**Airly Coal Expansion - Airly Mine MOD 3 - Production, Workforce and Train Movement  
Increases (SSD-5581-Mod-3) (Lithgow City)  
Environmental Assessment**

Simon Francis  
Senior Project Officer, Assessments  
**Water – Strategic Relations**  
21 February 2020

**Airly Coal Expansion - Airly Mine MOD 3 - (SSD-5581-Mod-3)  
Environmental Assessment**

Figure 2 Predicted mine inflows under approved and proposed conditions

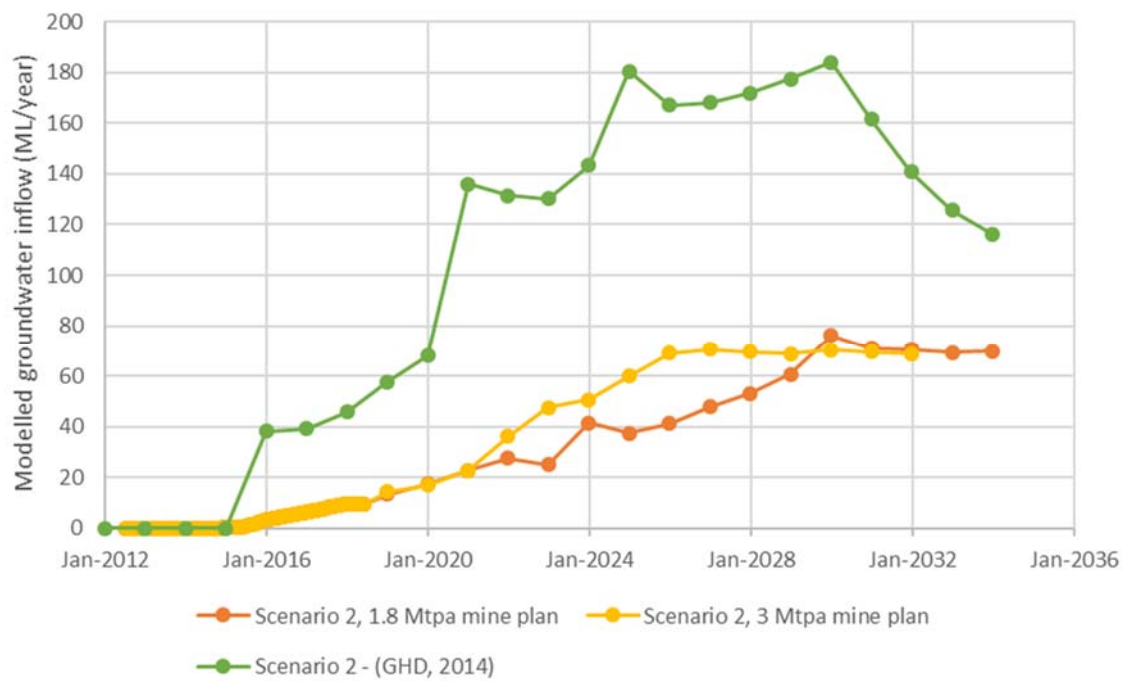
1. Revise the Numerical Groundwater Model by incorporating all monitoring data up to the end of 2019 and the altered mining methods for the revised future mining plan and panels (i.e. post 2017) including, as a minimum fracturing patterns consistent with 'Scenario 2'.
2. Prepare a comprehensive discussion of any variations noted compared to the outcomes for the 2018 model variant. The report should include a discussion of altered impacts arising from an increased presence of active subsidence fracturing with resulting hydraulic connection to shallow aquifers and surface water systems. A revised assessment of impacts against the criteria of the NSW Aquifer Interference Policy (2012) and an update on licensing requirements if required. Further analysis should be provided of the overlying 3<sup>rd</sup> order streams and how these are being considered within the groundwater model.

The now predicted inflows to the mine will extract a greater volume from the overlying aquifer systems; typically >20% additional, but up to 70% more per annum. The consequences of this appear to be a longer term draw down effect on (1) the Illawarra Coal Measures (the Lithgow Seam being mined is at the base of these); and (2) the underlying Shoalhaven Group strata.
